Hideaway Resort, AL-20-13

Please accept the following comments from El Paso County Public Health (EPCPD) for an amendment to the 2009 approved special use request and the special use requests contained in the referenced project above:

SITE PLAN P2 OF 2

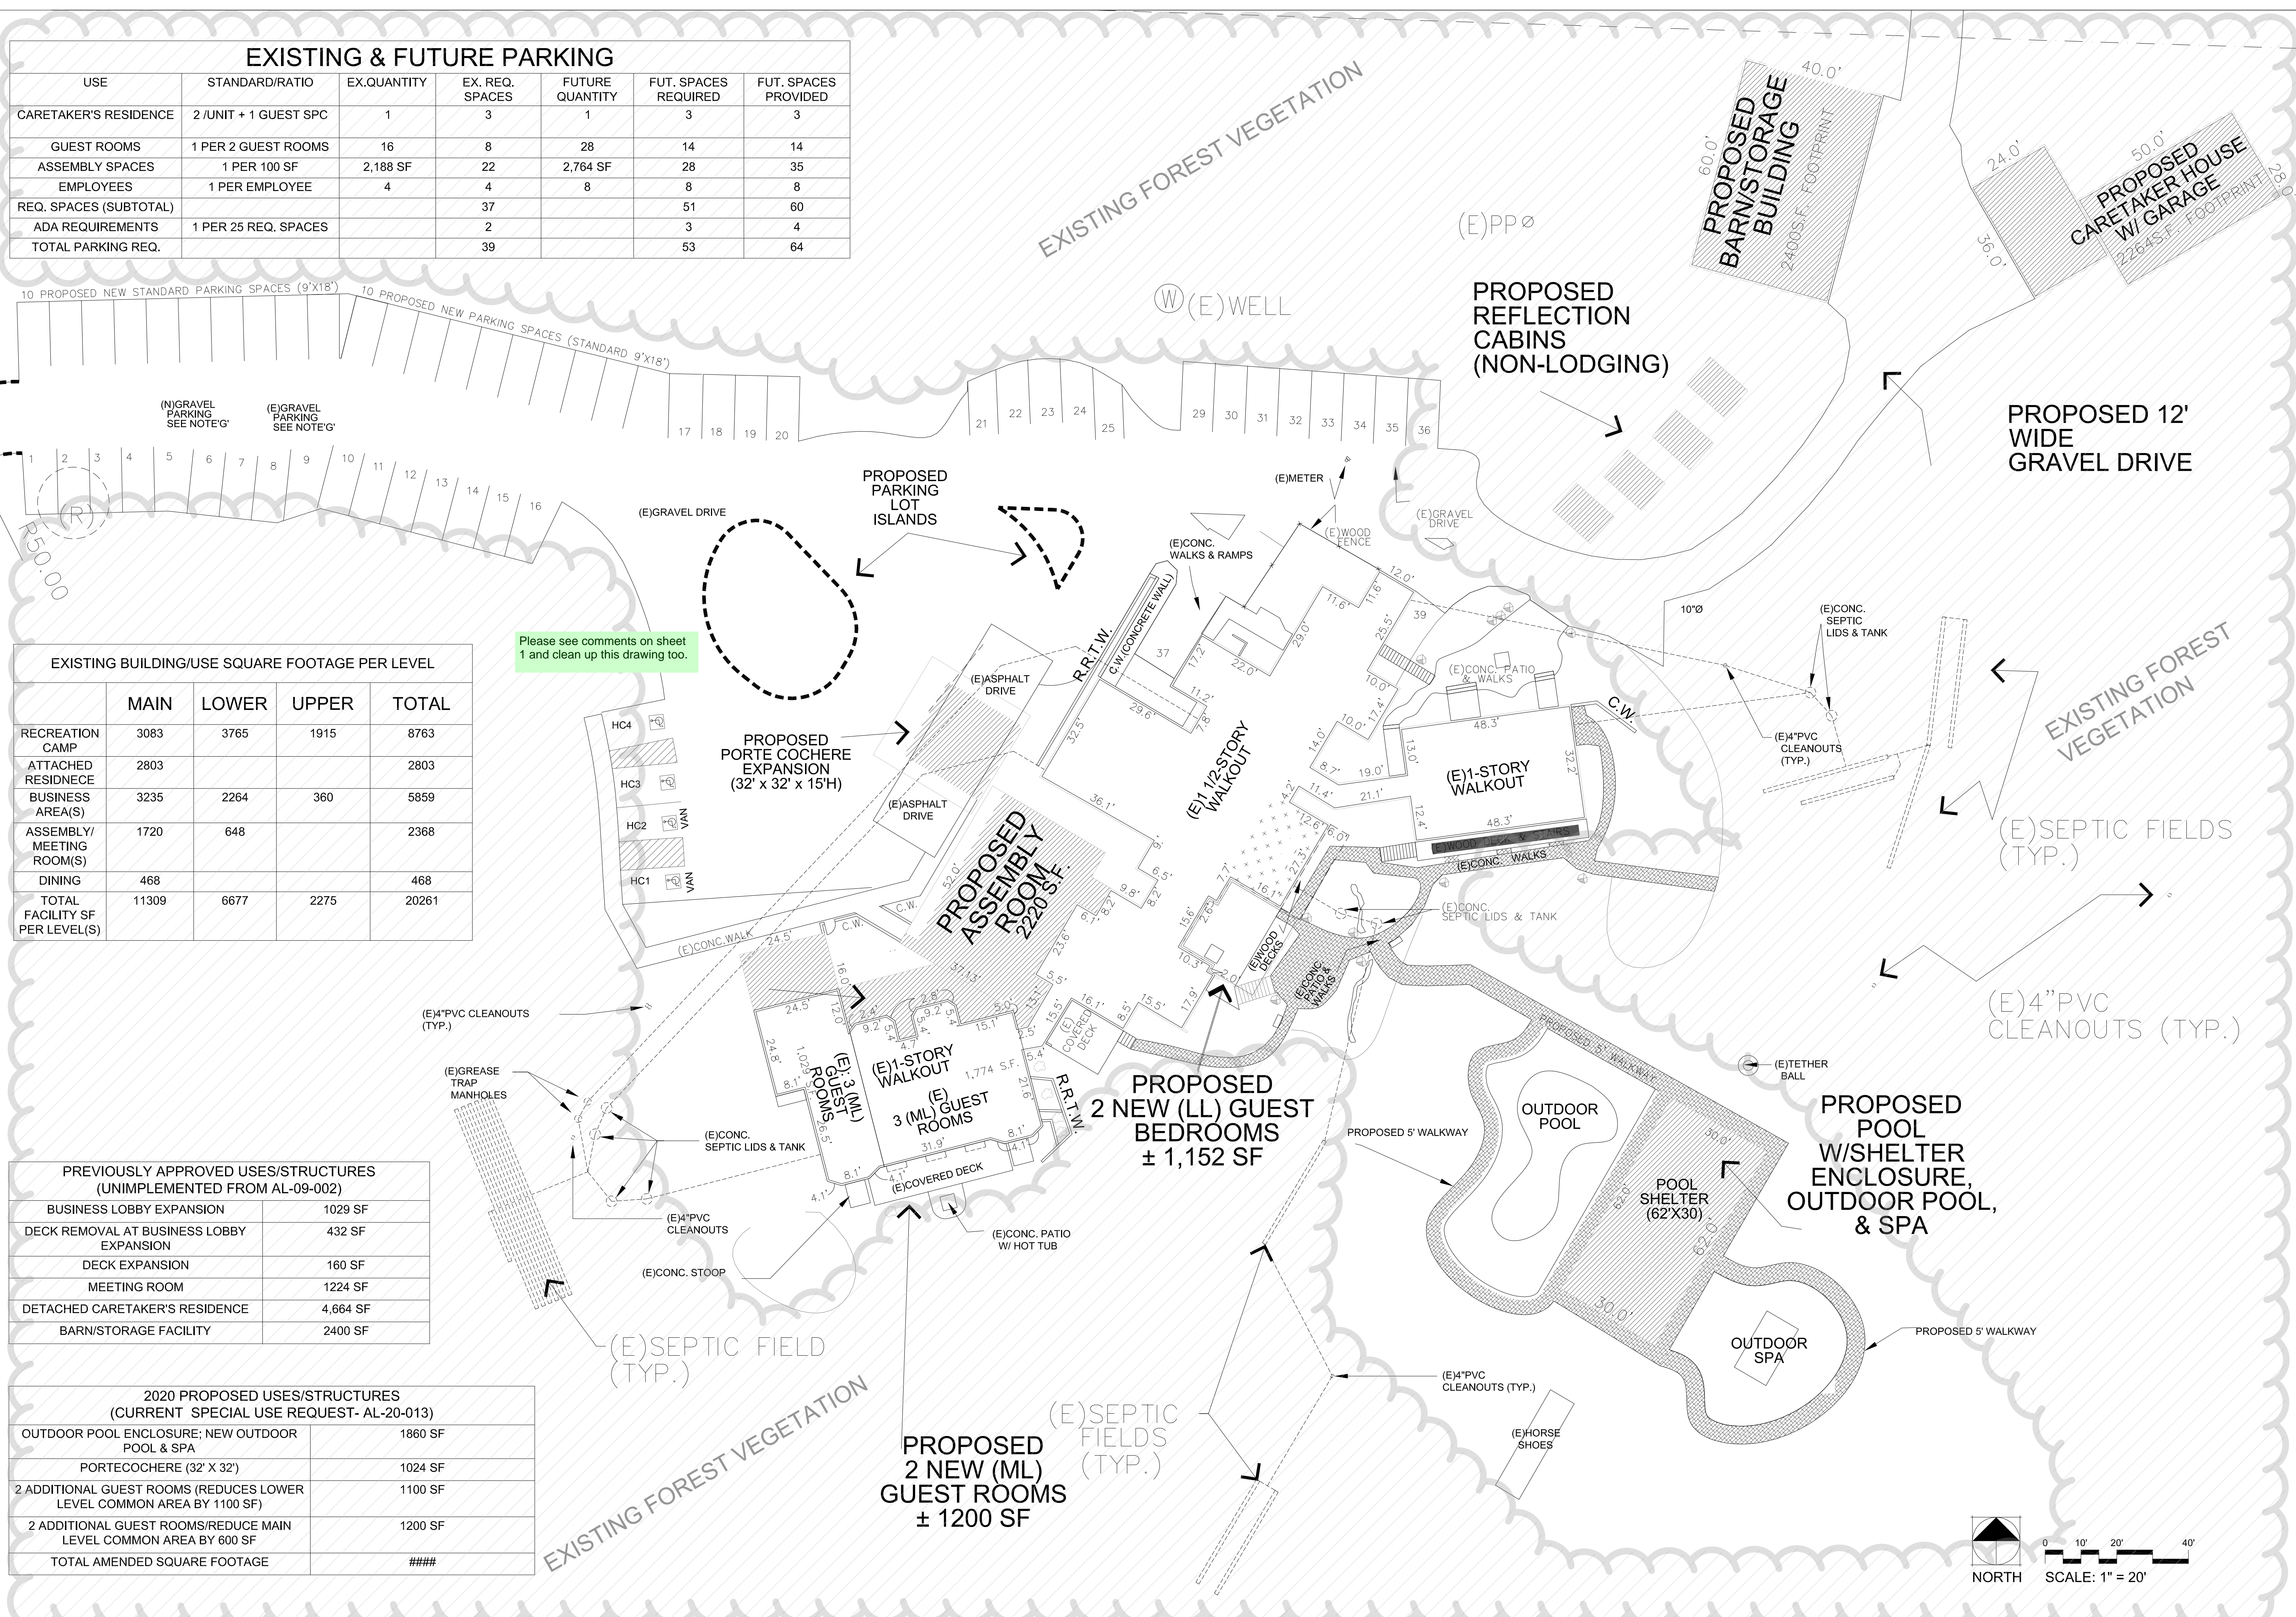
- Water for the site is provided by an individual well and is classified as a Transient, Non-Community Ground Water System by the Colorado Department of Public Health and Environment (CDPHE) and has been assigned PWSID #CO0221338. The CDPHE, Water Quality Control Division, must be notified of the proposed change in the population served so they can update their records.
- Phase V: Suggest having the larger pool enclosure reviewed by our Department just to assure the pool/spa deck clearances are satisfied.

The plans for the proposed inground pool and spa must be submitted to El Paso County Public Health for review and approval prior to construction.

- Phase VIII: A Colorado Registered Professional Engineer must submit an evaluation of the affects the guest room additions, the increase in the maximum number of guests from 100 to 115, the increase in the number of overnight guests from 50 to 56, and the proposed addition of wedding events will have on the existing onsite wastewater treatment systems (OWTS's). Any increase in any soil treatment area (STA) size will require a Major Repair Permit. This evaluation must include the new calculated setbacks of the affected STA's to the existing well.
 - The approval of permits to be issued by the PPRBD for the interior remodeling are contingent upon verification of the adequacy of the existing onsite wastewater treatment systems (OWTS) and/or possible approval of OWTS expansion permits.
